From: Laura Gibbons <Laura.Gibbons@arun.gov.uk>
Sent: 22 June 2021 15:00
To: Planning.Responses <Planning.Responses@arun.gov.uk>
Cc: Simon Davis <Simon.Davis@arun.gov.uk>
Subject: RE: Planning Consultation on: AL/20/21/PL

Application No: AL/20/21/PL
Registered: 18th February 2021
Site Address: Land At Wings Nursery Lidsey Road Woodgate PO20 3SU
Grid Reference: 493715 104134
Category: Plan Applicat'n
Description of Works: Demolition of Wings House & erection of 71 No. replacement dwellings (70 net new dwellings), access arrangements, sustainable drainage measures, public open space, landscaping & all other associated works (resubmission following AL/46/20/PL). This application is a Departure from the Development Plan.

DRAINAGE STRATEGY

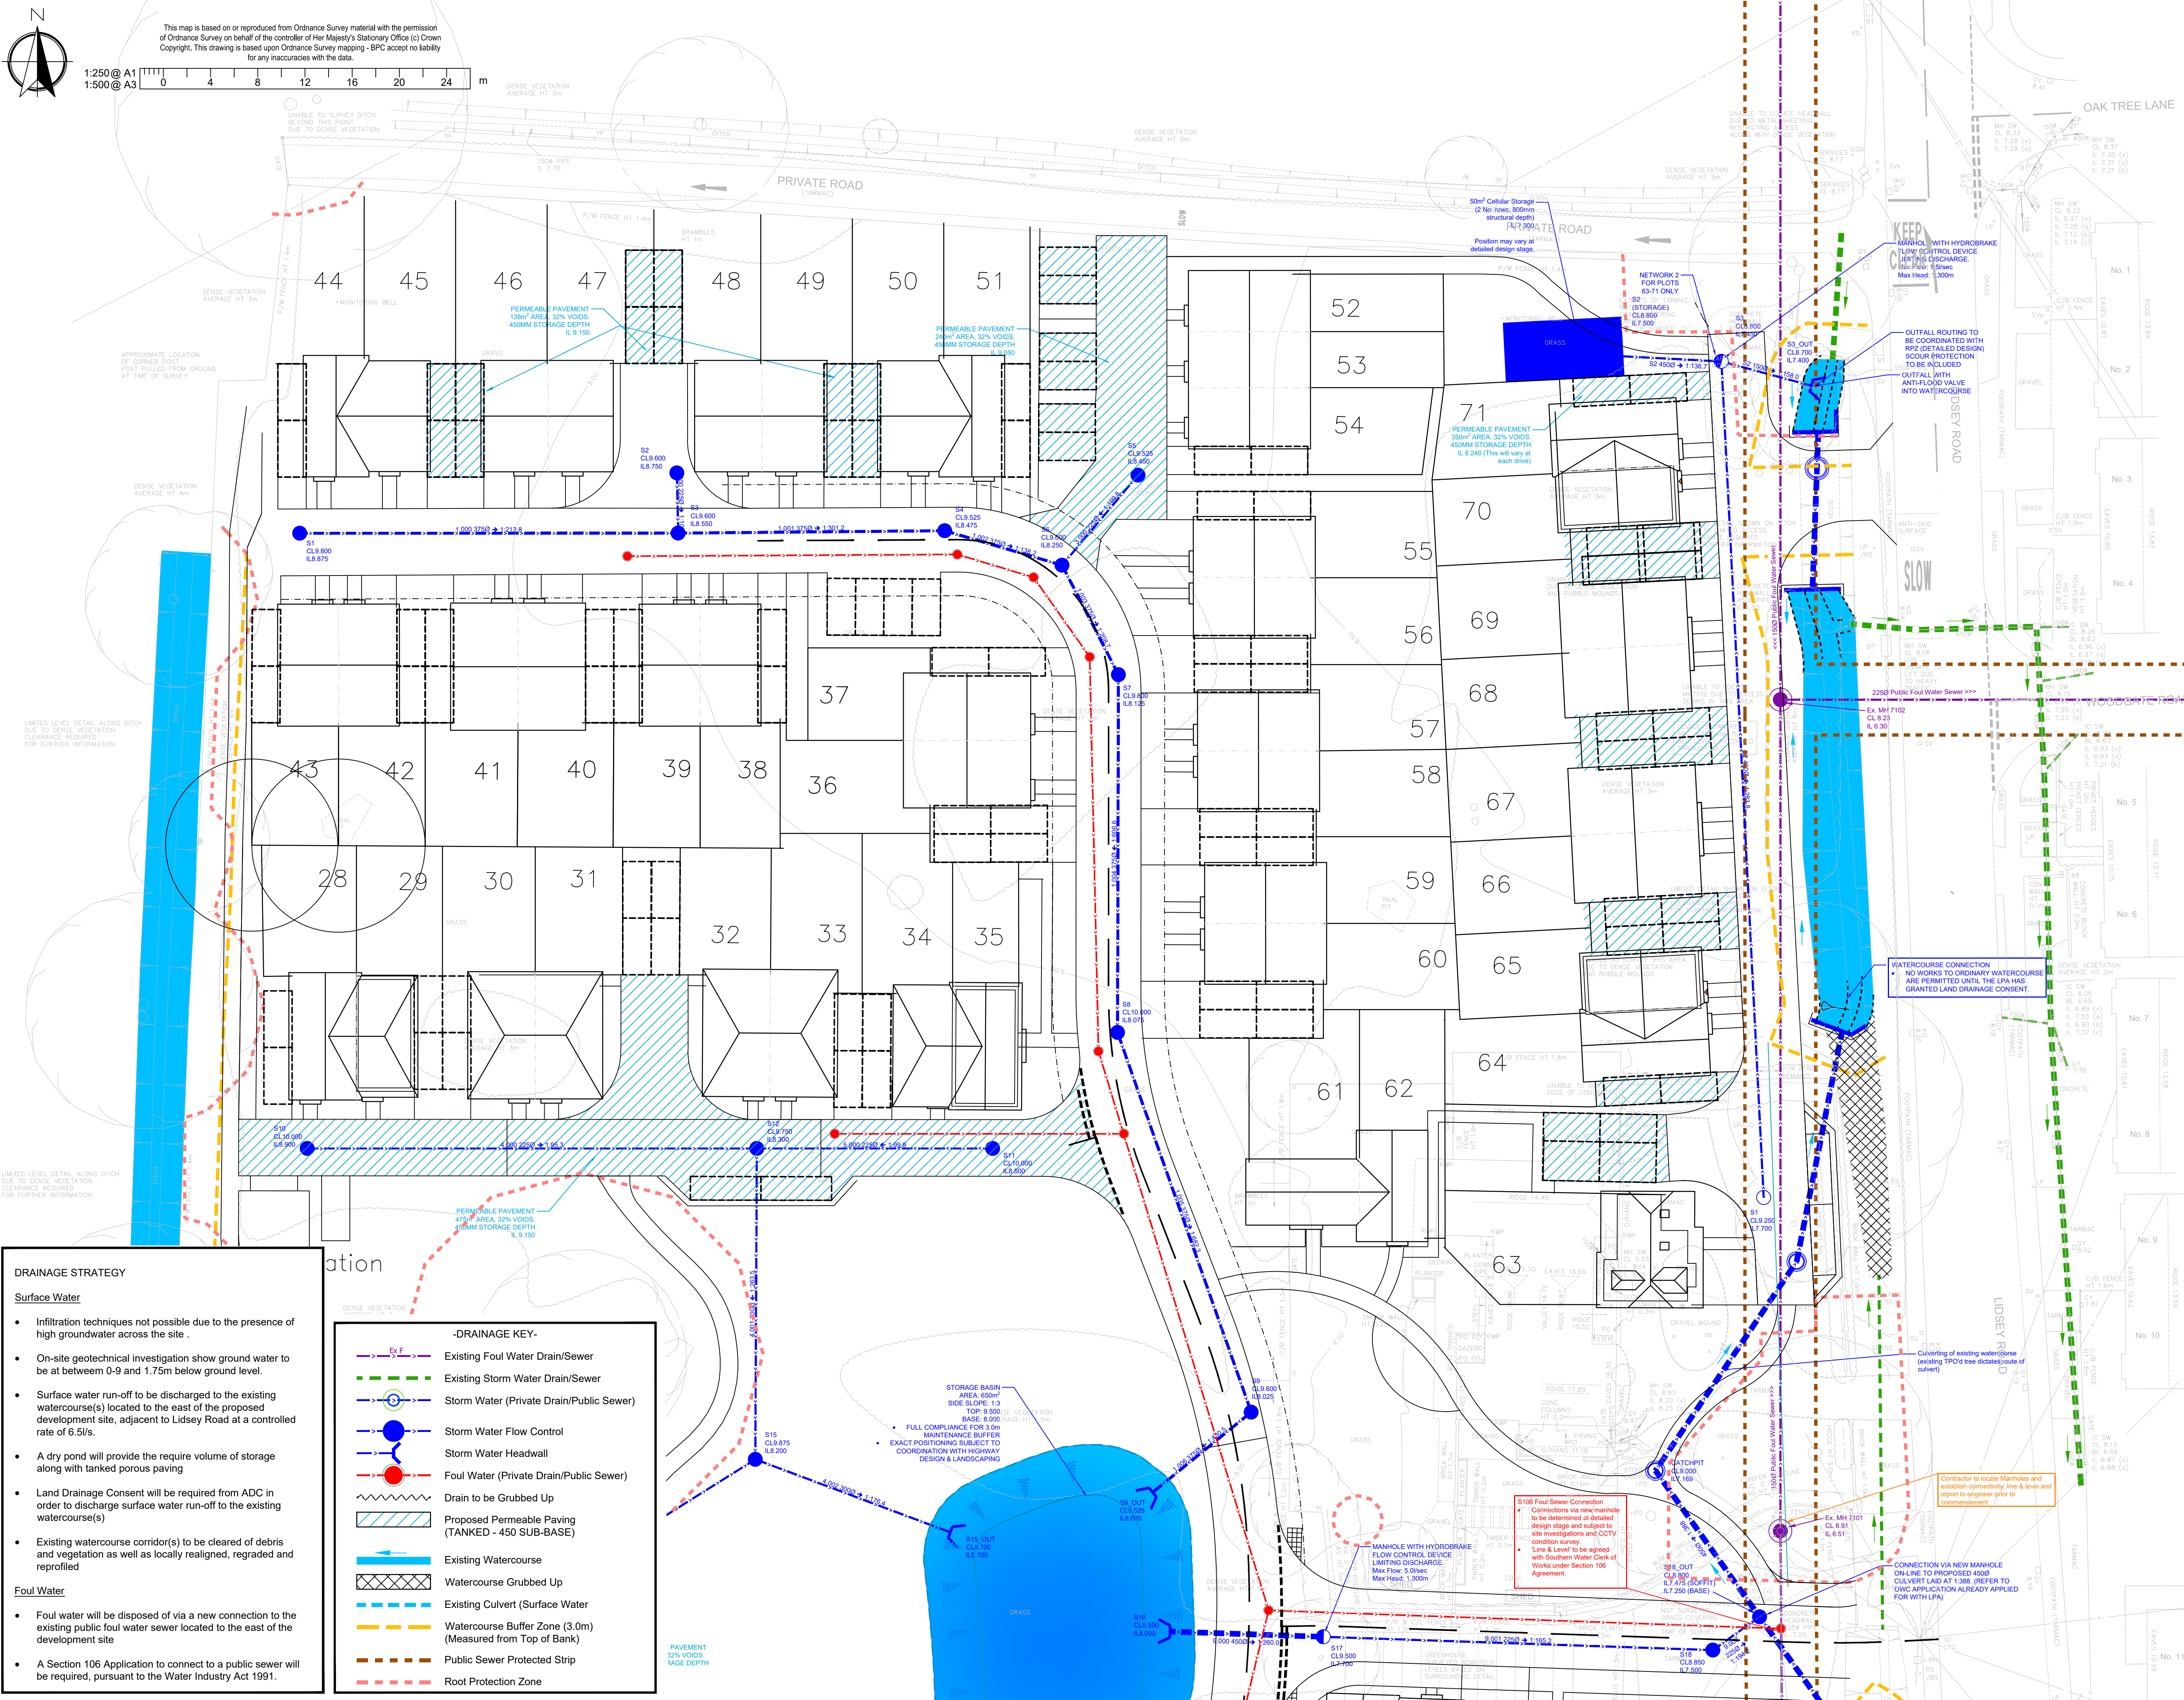
Thank you for reconsulting us on this application. We have been in discussions with the applicants engineer about our original consultation response, we are pleased that a number of points have been satisfactorily resolved. However, there still appears to be conflict between the drainage and proposed landscaping. There is a tree proposed over the attenuation tank, and several trees are proposed immediately next to/ within the attenuation basin. Please can the applicant provide a revised landscaping strategy with all proposed trees clear of proposed drainage features. Drainage features should not be proposed within root potential areas.

However, if you are minded to approve this application prior to the supply of revised landscaping proposals then please ensure that the drainage plans are not listed as approved and that the following standard drainage conditions are applied: PCENG2, PCENG3, PCENG4, and ENG1.
